## Proposed Examination Foreclosure

The Applicant's Response to D4 Submissions [\[REP5-021\]](#) is no exception.

Figure 2. Illustrative MWh/day across a typical year for a 480MW dc scheme (based on 1990 weather data)

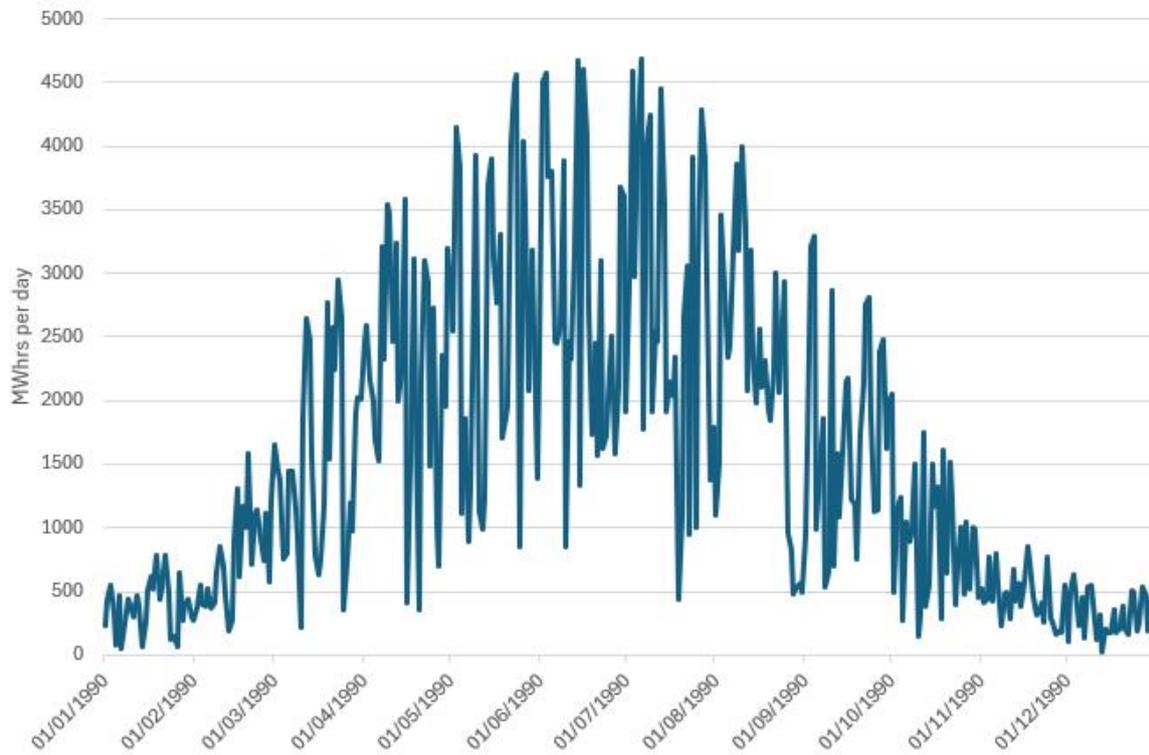
*Figure 1 [actually, 'Figure 2'] provides a sample illustration of the MWh per day that may be produced by a 480MW dc scheme (based on 1990 irradiance levels - the generation will vary year on year depending on weather conditions) etc ...* [page 20; also Tech Note page 7].

The authenticity of this graph in the Technical Note had been shown to be questionable, with implications for the Applicant's claimed familiarity with PVsyst [\[REP4-036, 2.1.4\]](#). Repeating the original text verbatim is not an insightful response.
